17 December 2014

Roads and Maritime Reference: SYD14/00776/02(A8157043)
Council Ref: SSD6603

SITE 68 MIXED USE DEVELOPMENT, SYDNEY OLYMPIC PARK SSD 6603

80014010 SK001  
PROPOSED MIXED-USE DEVELOPMENT  
SITE 68, SYDNEY OLYMPIC PARK  
VEHICULAR ACCESS TO  
BASEMENT PARKING SPACES  
M.D. 15.09.2014

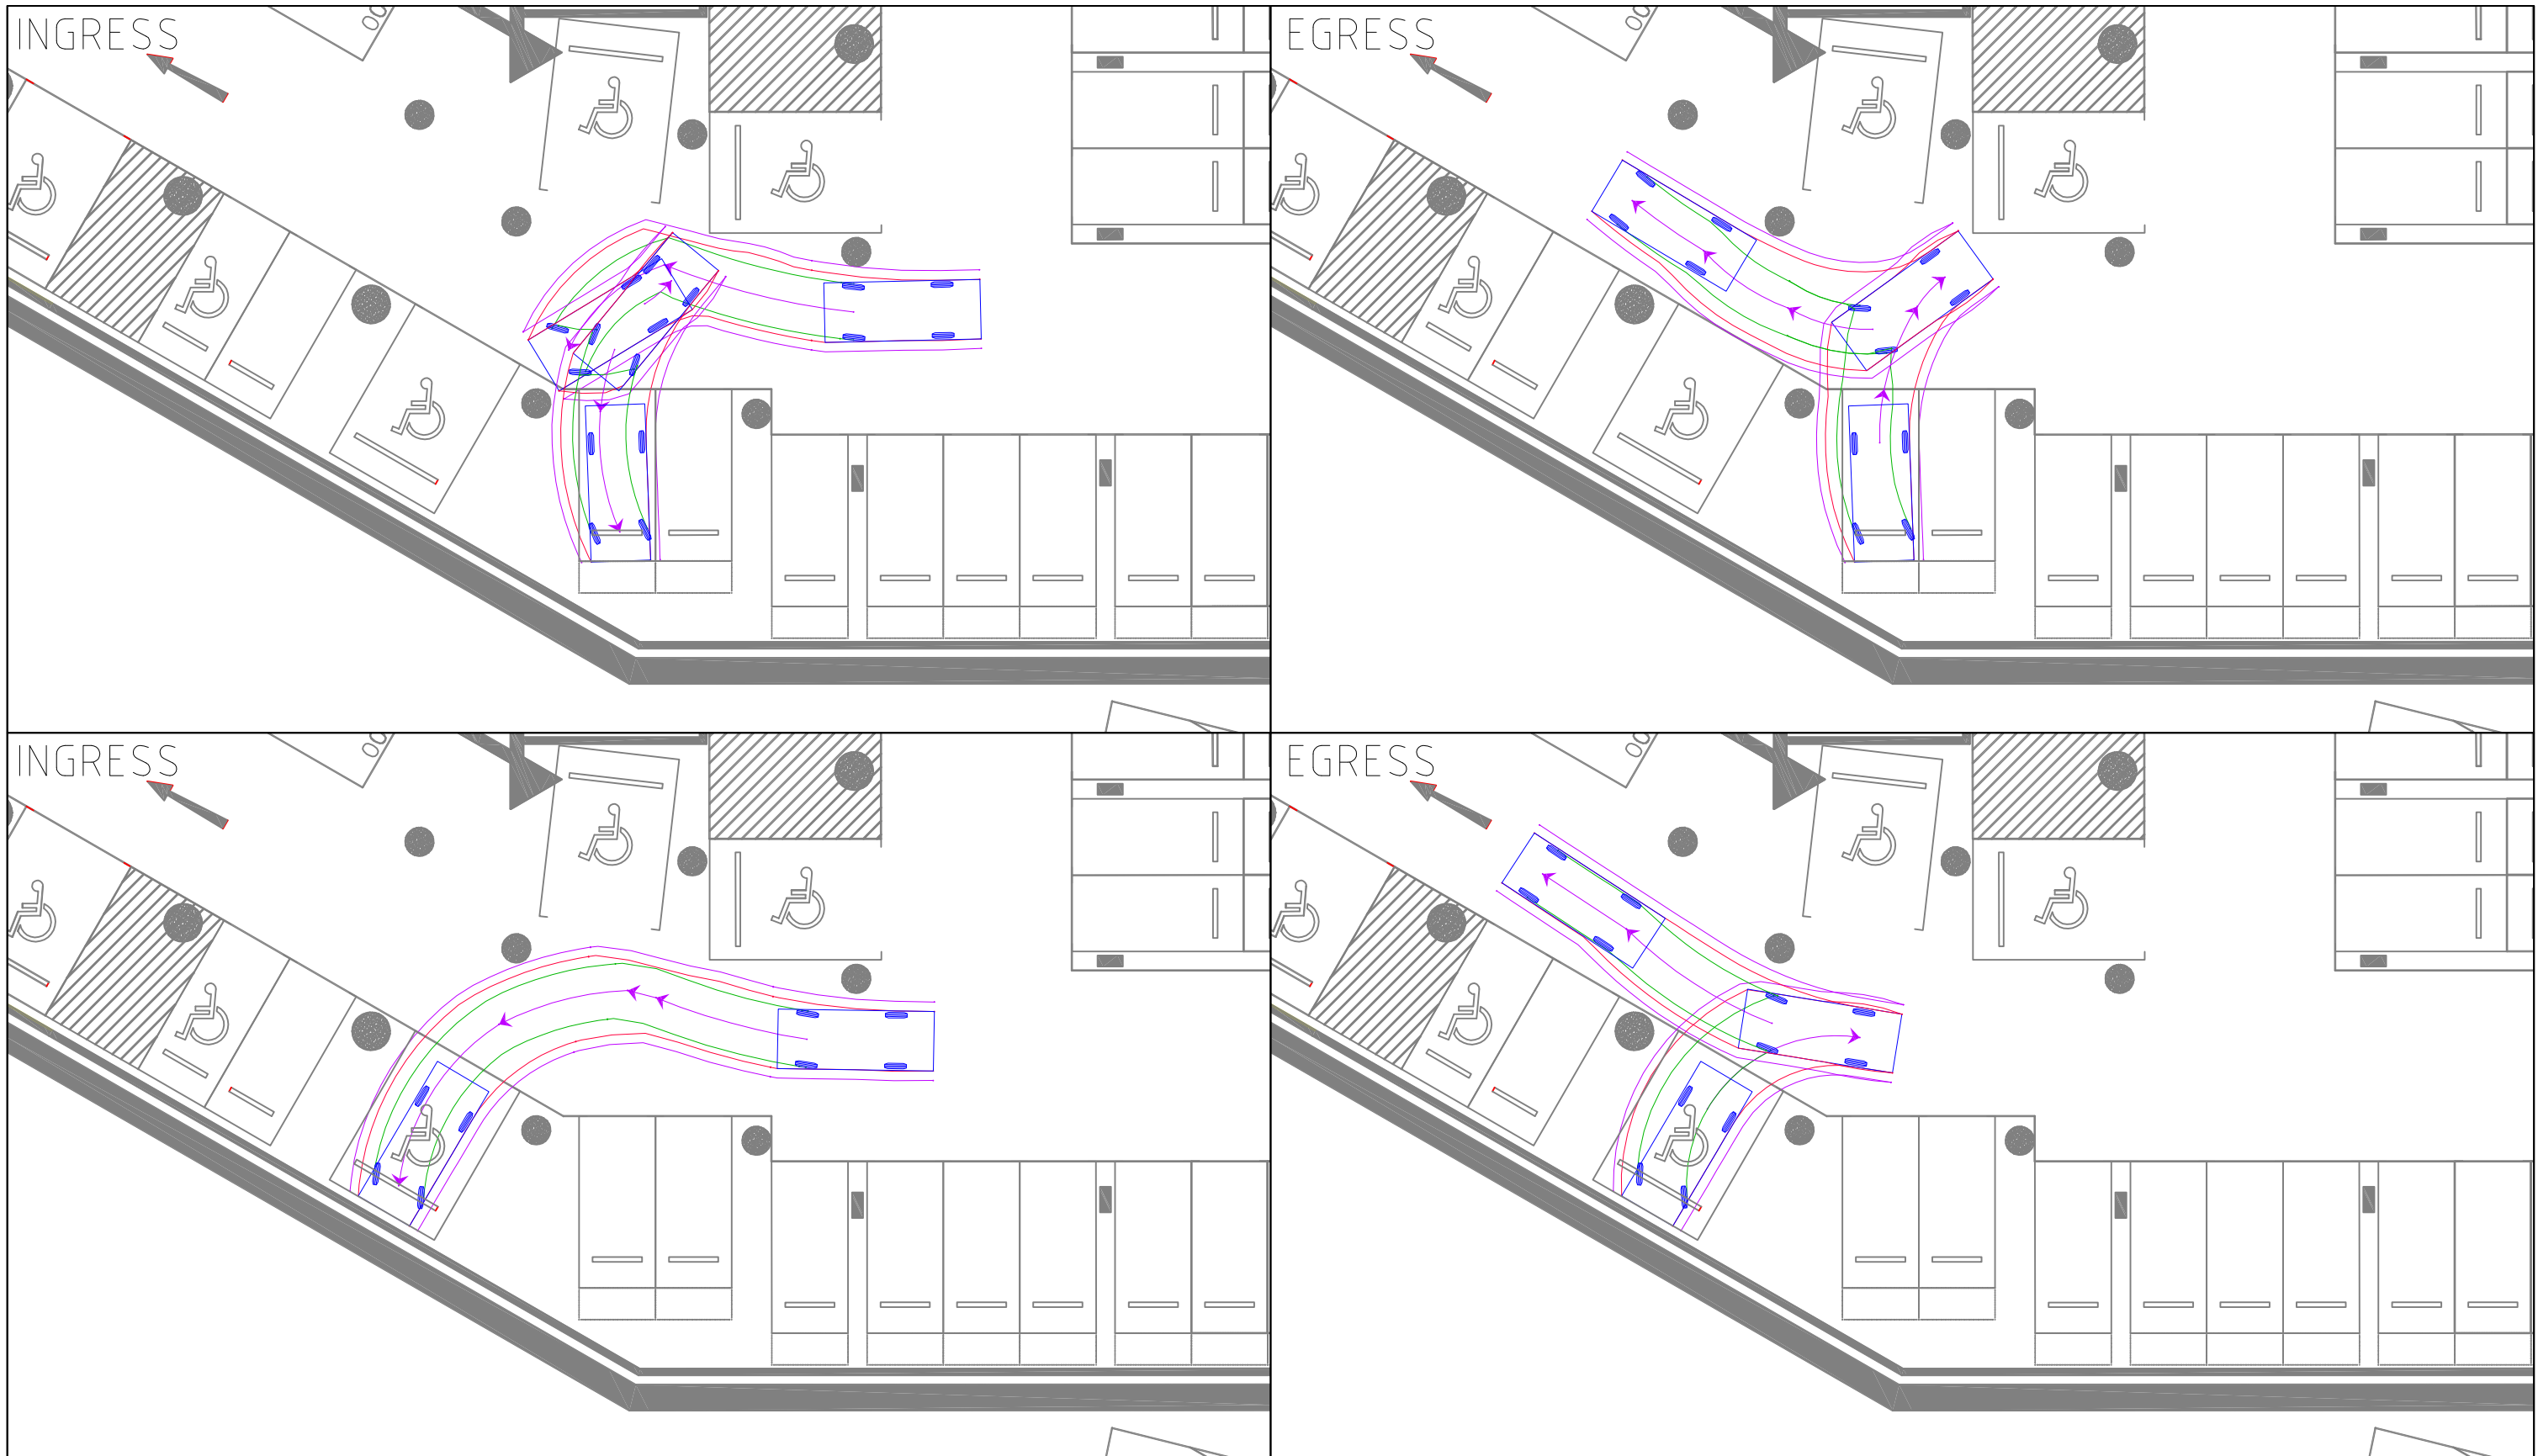
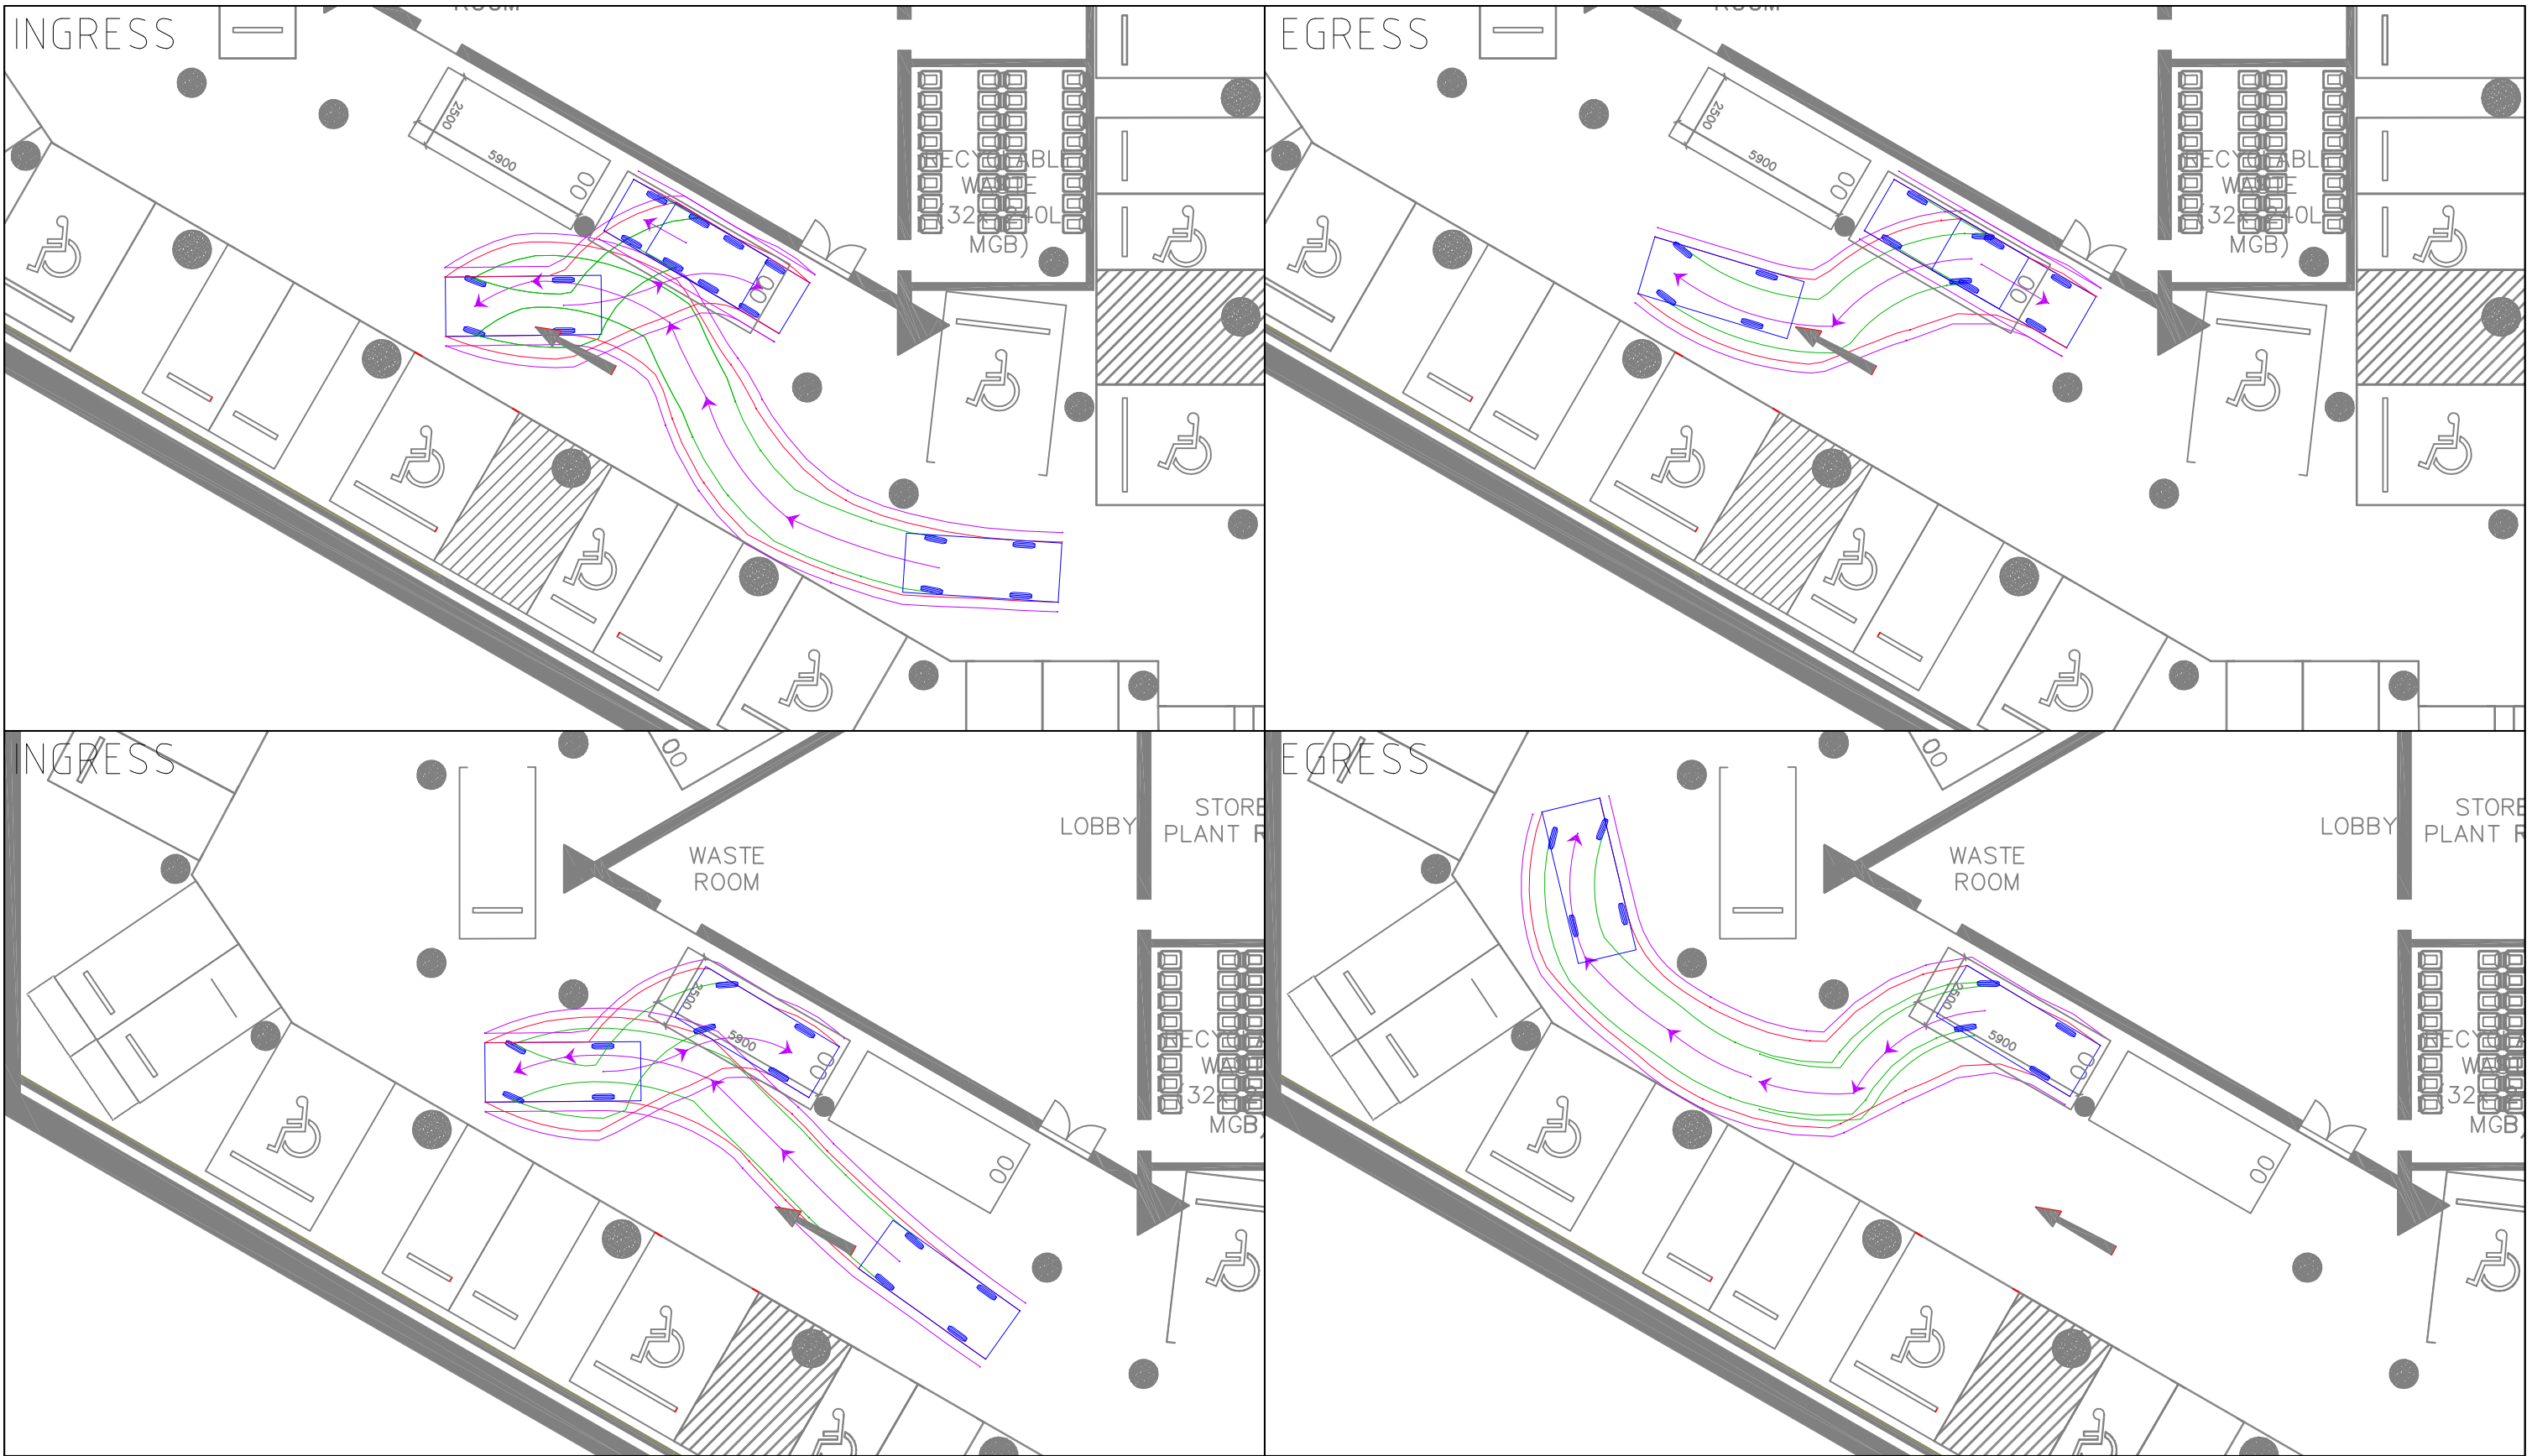
1. The proposed development at Site 68 shall comply with the approved Sydney Olympic Park Master Plan 2030.
2. The layout of the proposed car parking areas, loading docks and access driveway associated with the subject development (including, driveways, grades, turn paths, sight distance requirements, aisle widths, aisle lengths, and parking bay dimensions) should be in accordance with AS 2890.1- 2004 and AS 2890.2 – 2002 for heavy vehicle usage.
3. A Construction Traffic Management Plan detailing construction vehicle routes, number of trucks, hours of operation, access arrangements and traffic control should be submitted to Department prior to the issue of a construction certificate.
